Re: Jefferson Hotel
Tract 2A3C1 & 2A3C2, Jefferson & Restaurant Lane
Traffic Circulation Layout
Engineer's/Architect's Stamp 07-30-18 (F17-D044C)

Based upon the information provided in your submittal received 07-31-18, the above referenced plan cannot be approved for Building Permit until the following comments are addressed:

JEFFERSON
HOTEL
TRAFFIC CONTROL
LAYOUT

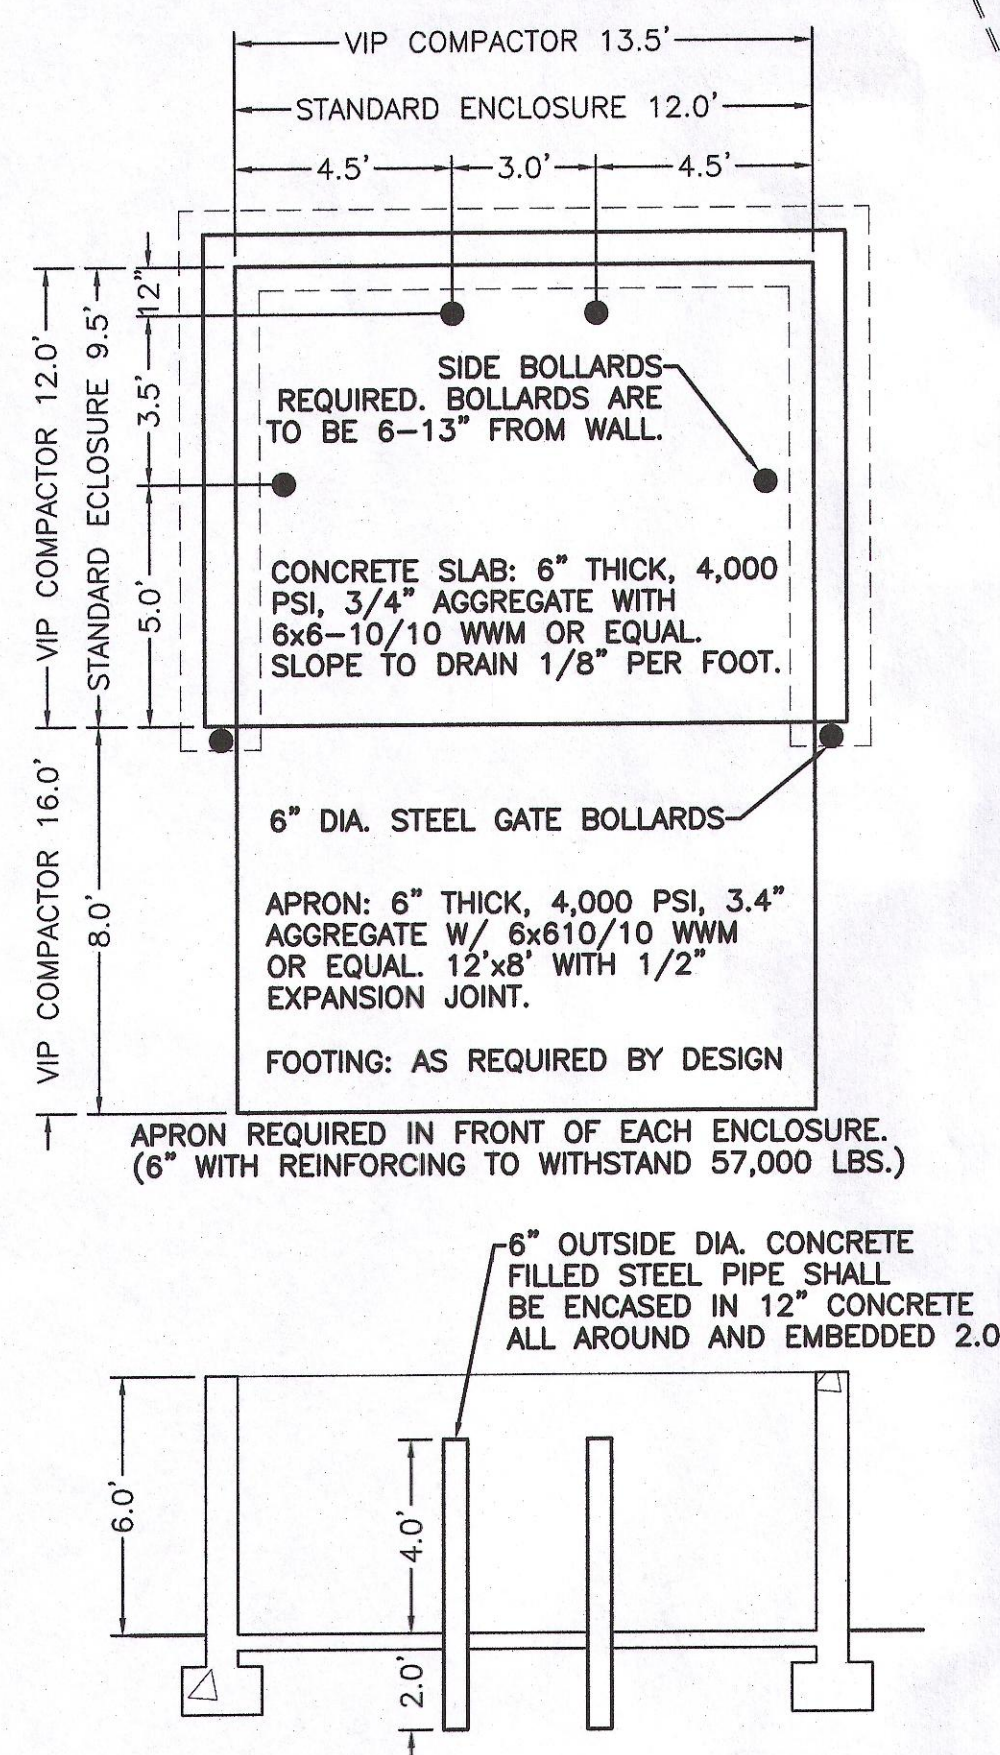
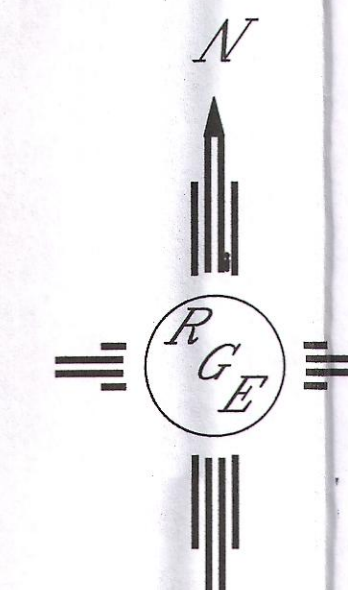
1. Please review and revise plan to provide all information listed on the Traffic Circulation Layout checklist.
2. Please refer to the Accessible Parking Checklist and revise the plan accordingly.

3. Please refer to IDO regarding bicycle parking.
4. New access entrance off Restaurant Lane NE, please revise to 28 foot in width.
5. Please correct Motorcycle parking for Hotel under Site Data.

6. Please identify all existing buildings, doors, structures, sidewalks, curbs, drive pads, wall and anything that influences the parking and circulation on the site.

7. Identify all existing access easements and rights of way width dimensions.
8. Please list the width and length for all existing and proposed parking spaces. Some dimensions are not shown.

9. Van accessible aisles should be 8ft wide; all others should be 5ft wide.
10. The ADA accessible parking sign must have the required language per 66-7-352.4C NMSA 1978 **"Violators Are Subject to a Fine and/or Towing."** Please call out detail and location of HC signs.

11. Motorcycle parking spaces shall be designated by its own conspicuously posted upright sign, either free-standing or wall mounted per the zoning code.

12. Per the IDO, a 6 ft. wide ADA accessible pedestrian pathway is required from the public sidewalk to the building entrances. Please clearly show this pathway and provide details.

13. Design delivery vehicle route needs to be shown.

14. Service vehicle and/or refuse vehicle maneuvering must be contained on-site; provide a copy of refuse approval.
15. It is not apparent what type of pavement surface is being proposed. A hard driving surface will be required as part of this proposed project for parking area and drive aisles.

16. Show the clear sight triangle and add the following note to the plan:
"Landscaping and signage will not interfere with clear sight requirements. Therefore, signs, walls, trees, and shrubbery between 3 and 8 feet tall (as measured from the gutter pan) will not be acceptable in the clear sight triangle."

17. Please specify the City Standard Drawing Number when applicable.
18. Please include a copy of your shared access agreement with the adjacent property owner.

19. Add a note stating "All broken or cracked sidewalk must be replaced with sidewalk and curb & gutter." A build note must be provided referring to the appropriate City Standard drawing.
